From: Martyn White
Sent: 06 November 2018 16:41
To: Planning.Responses
Cc: Anita Gardner
Subject: CM/22/18/L

CM/22/18/L

Mill Thatch is a single storey, utilitarian structure with hipped roofs at both ends. The building was originally of 4 bays with a further 2 bays added at a later date. The roofing material is thatch.

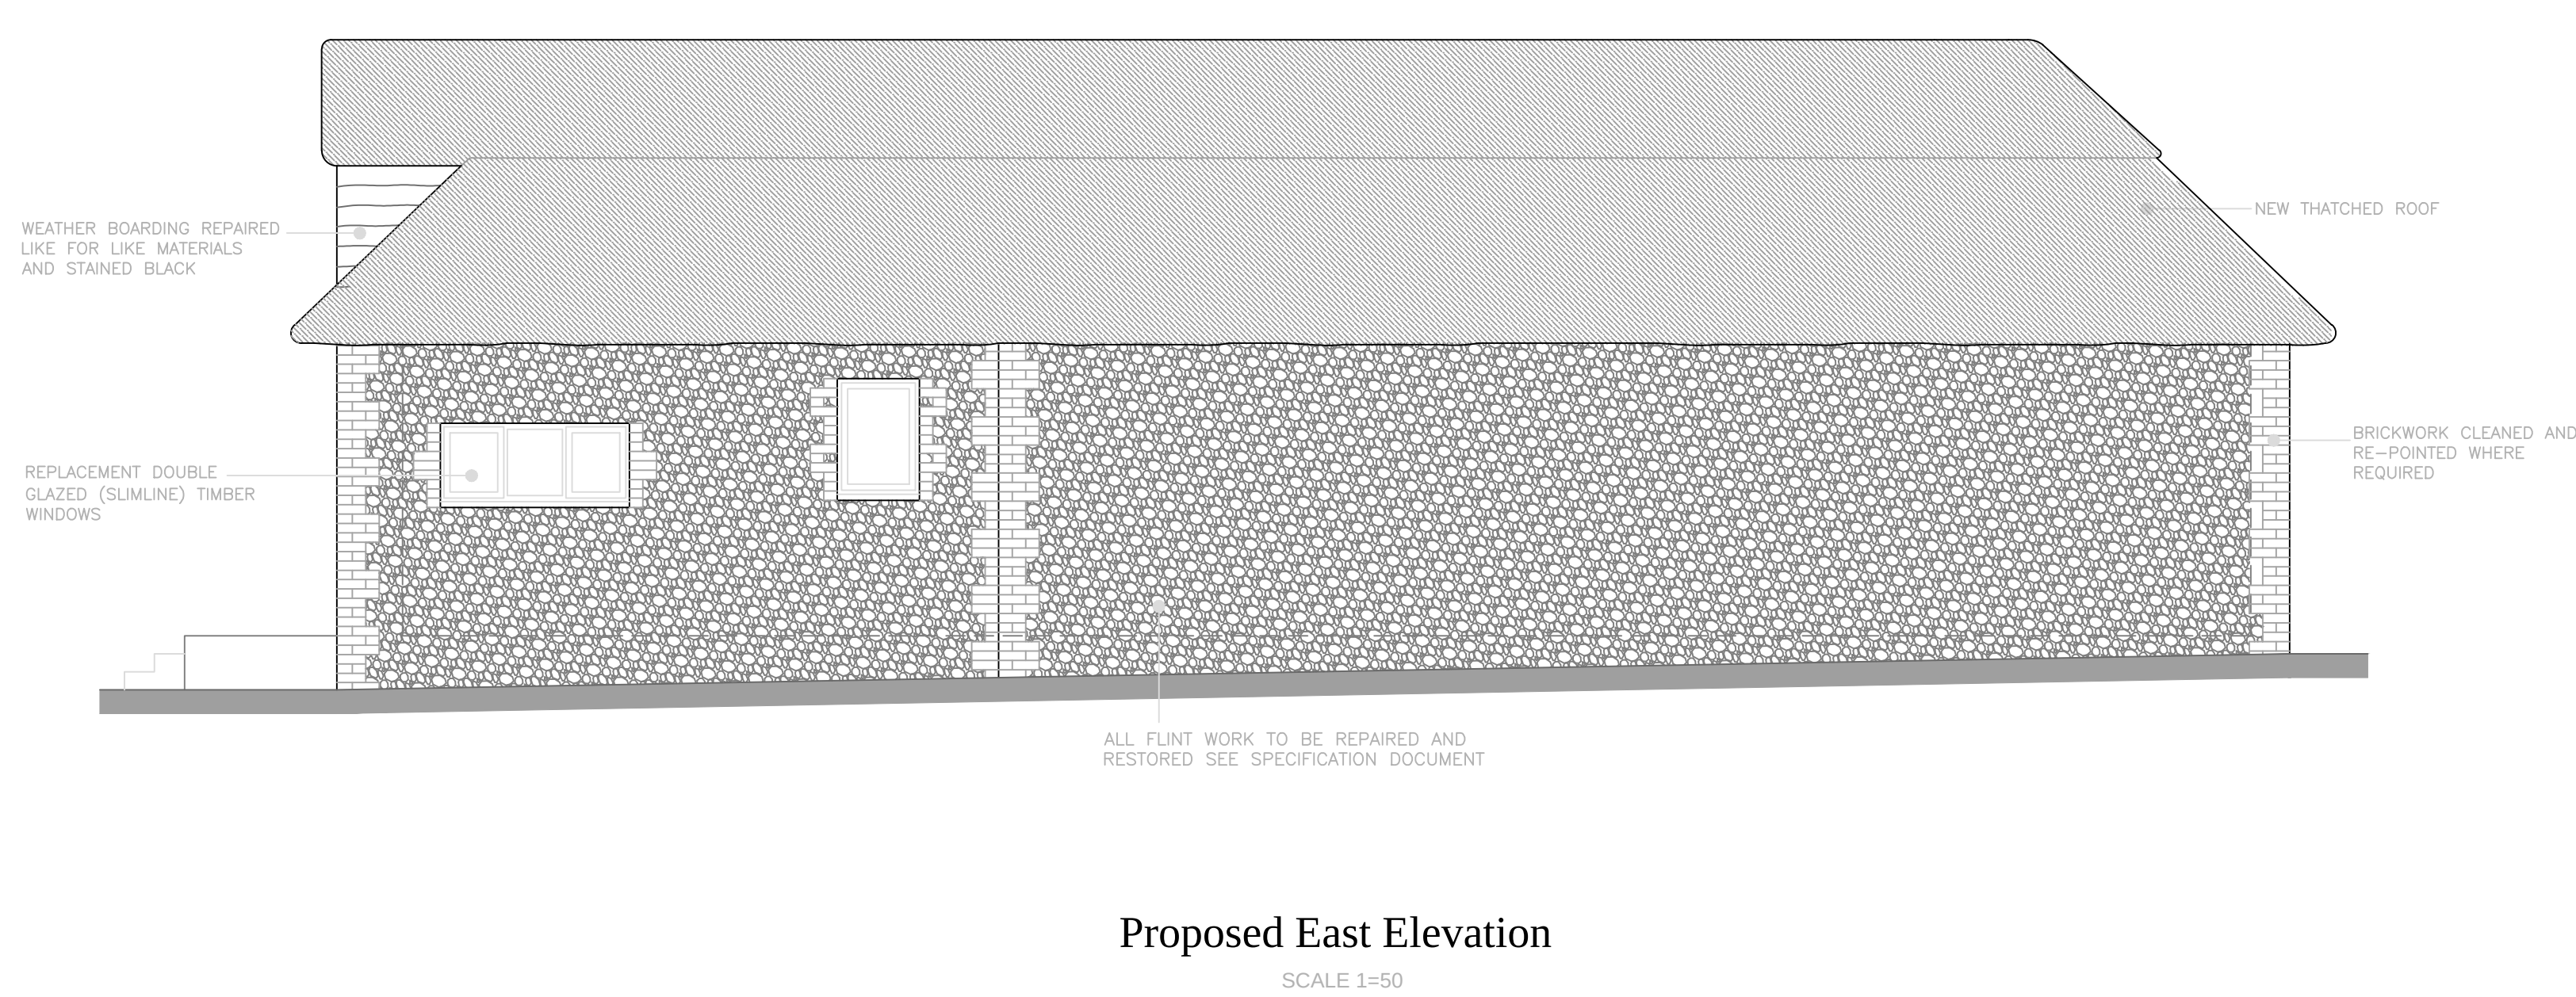
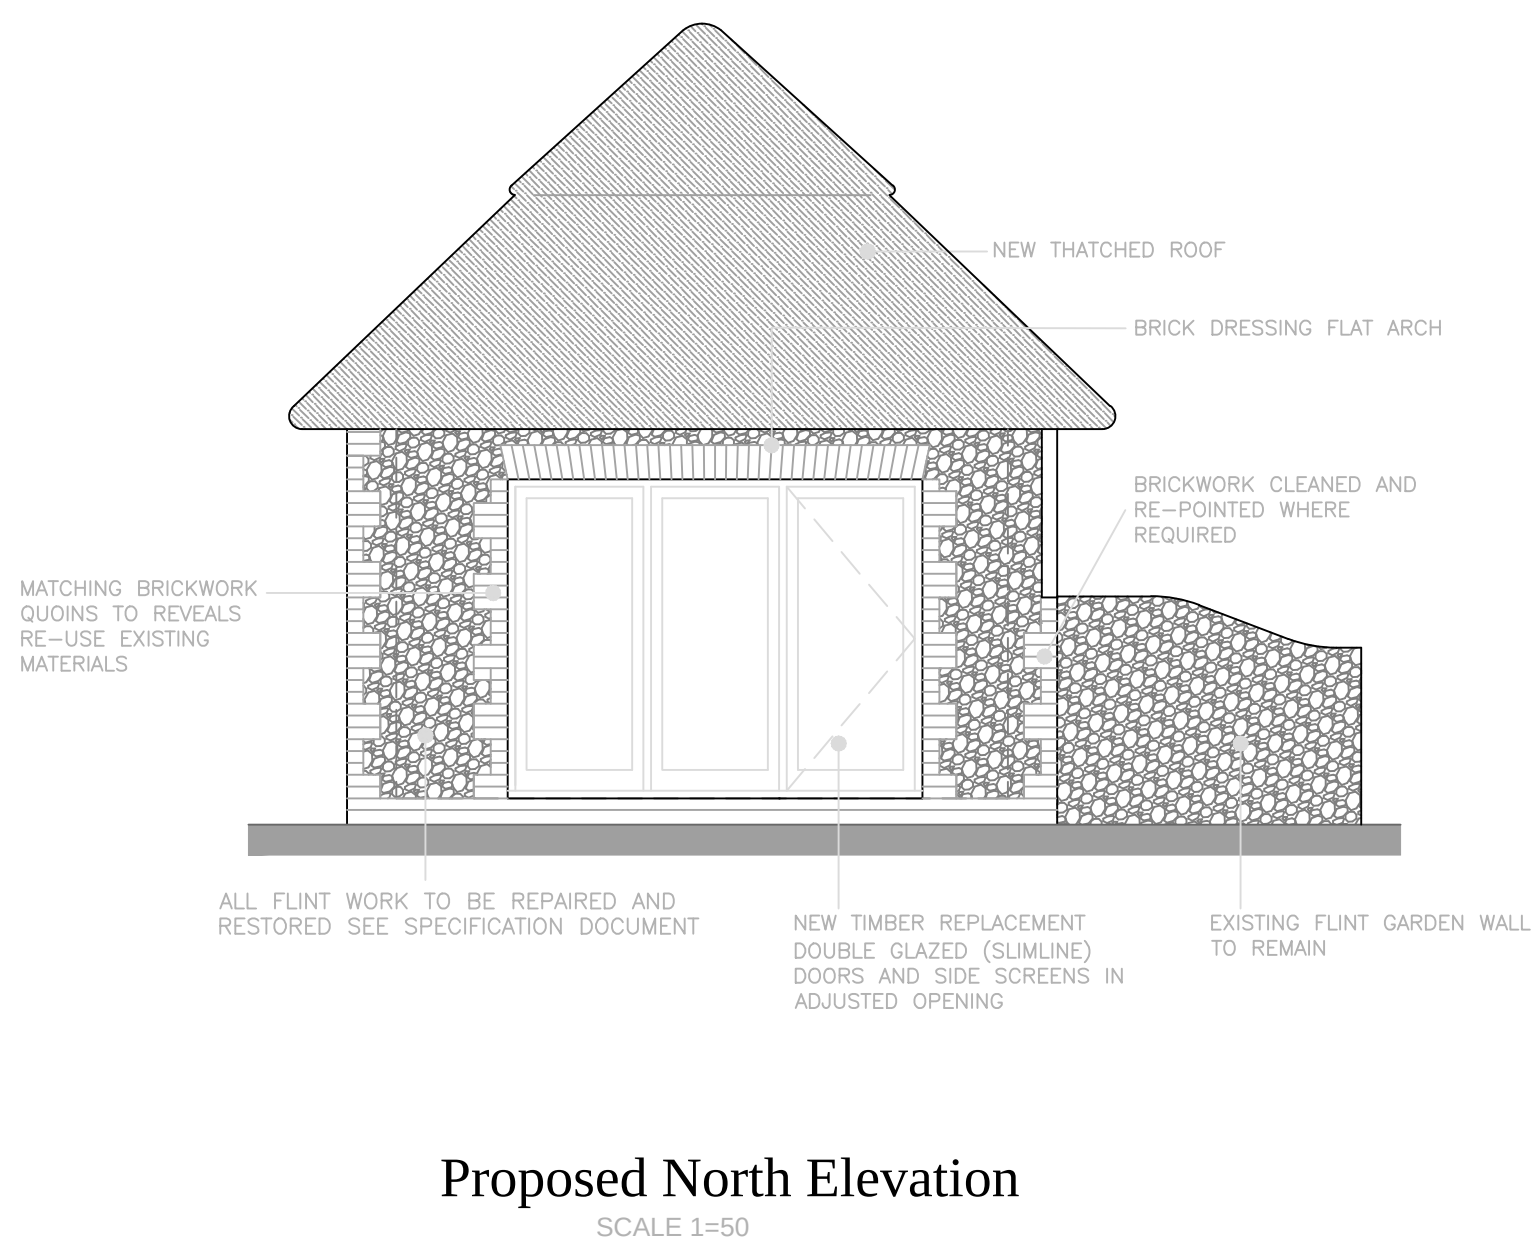
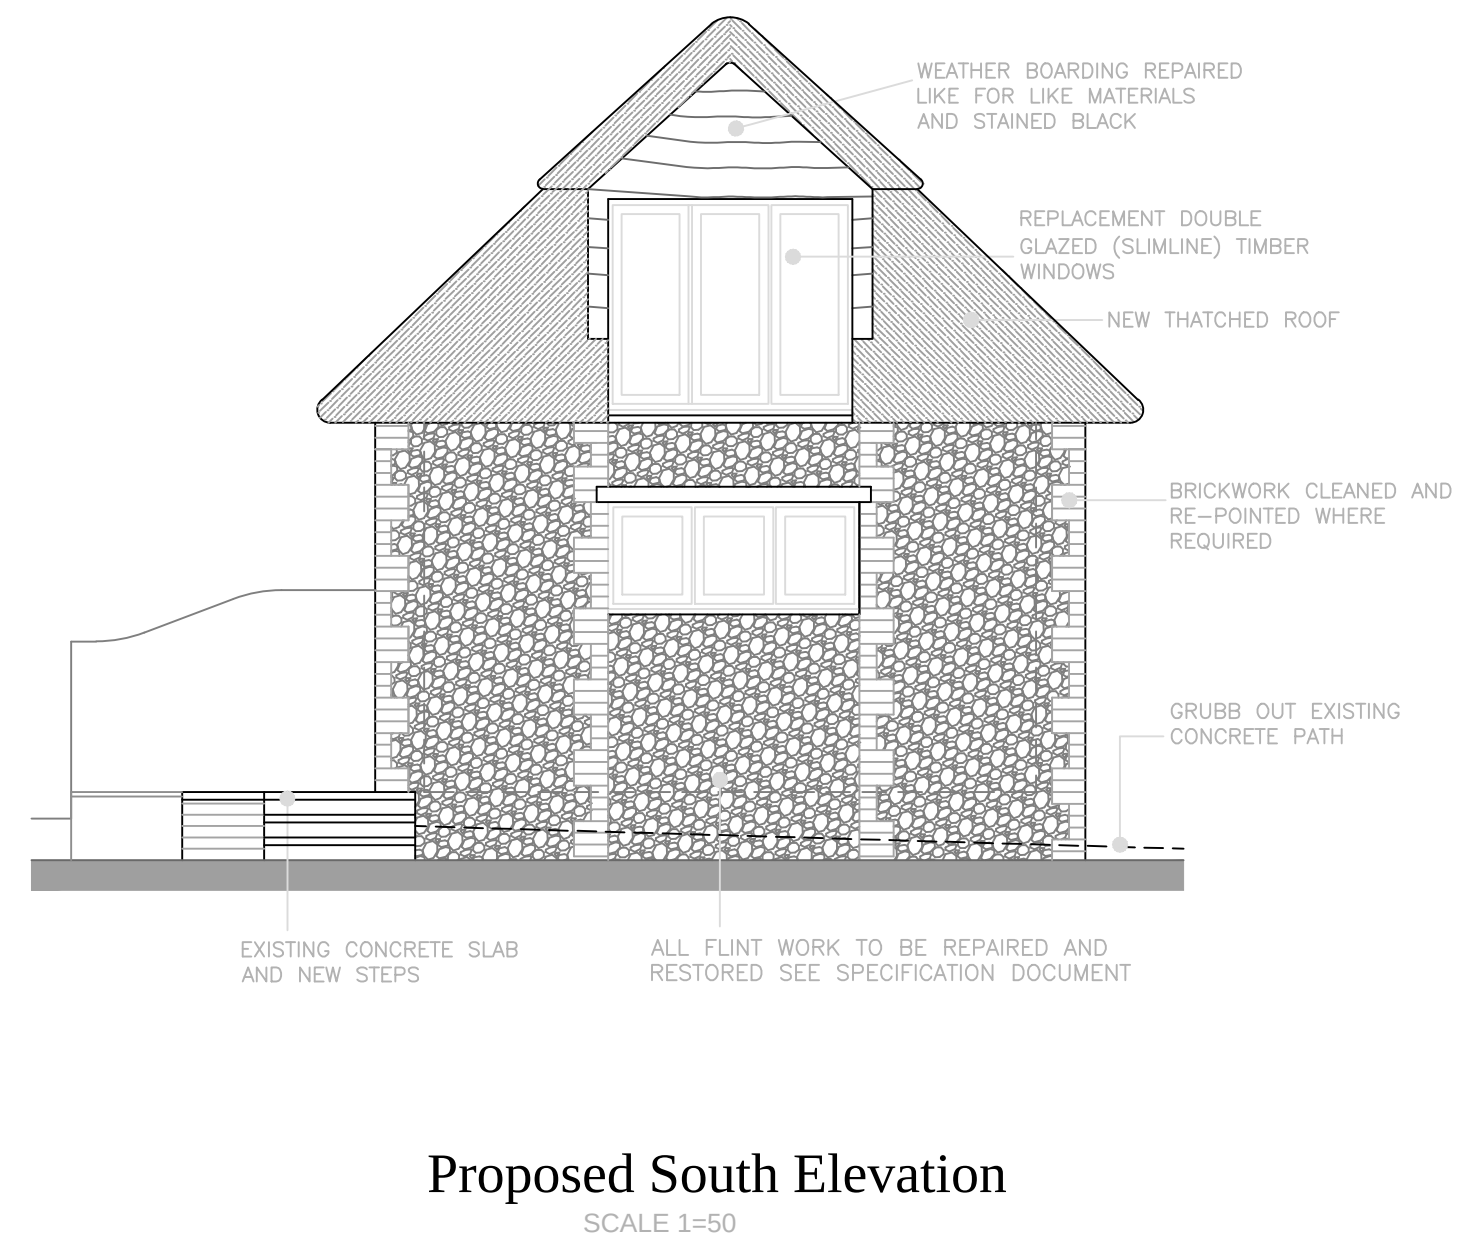
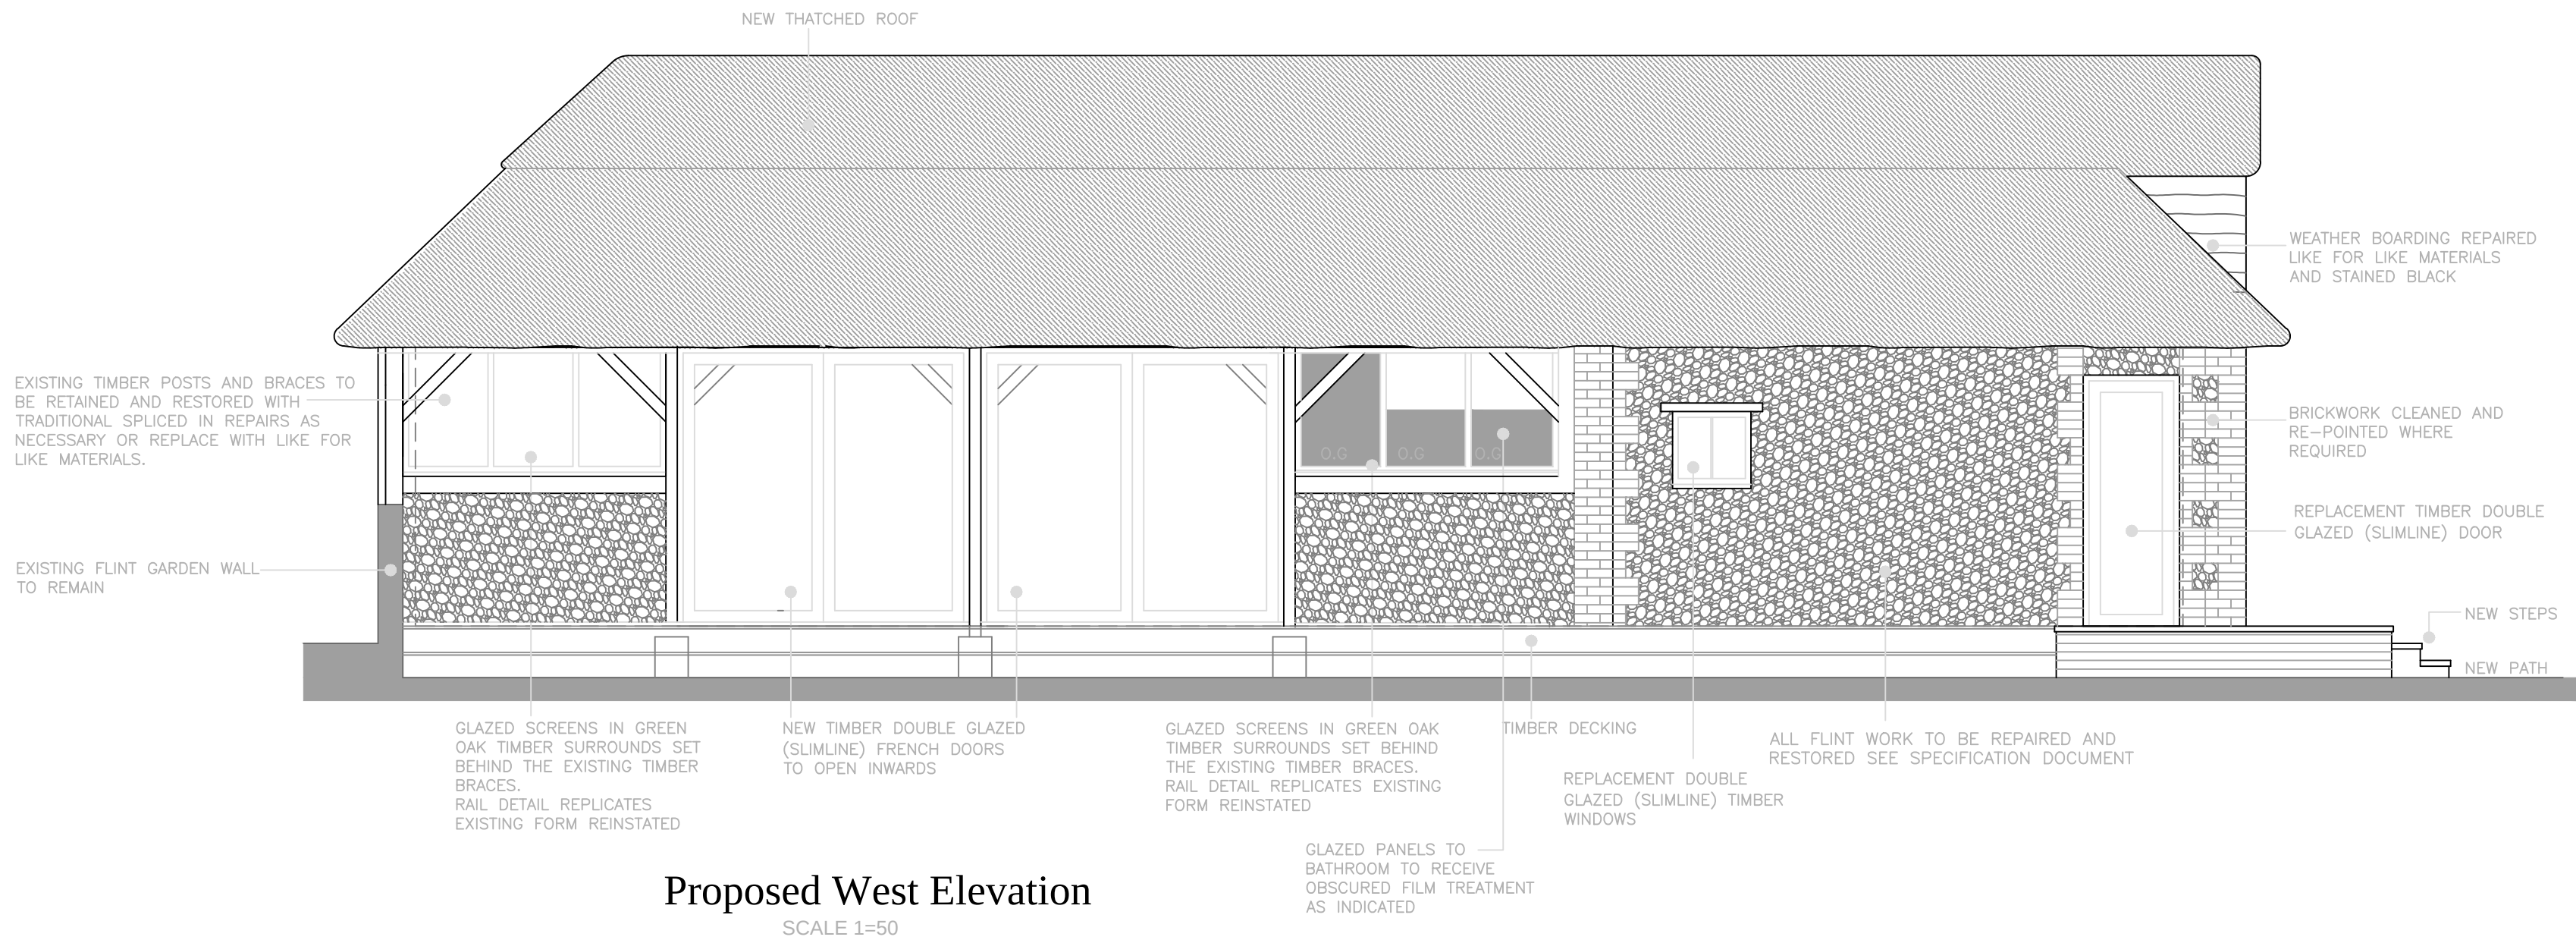
A decked area is proposed, and it is considered to be suitable, subject to details. I also note that there is to be a suspended feature log burning stove, but there doesn't appear to be any flue on the elevations. Is this correct, or is one required which hasn't been identified on the plans? Such a feature will require Listed Building Consent?
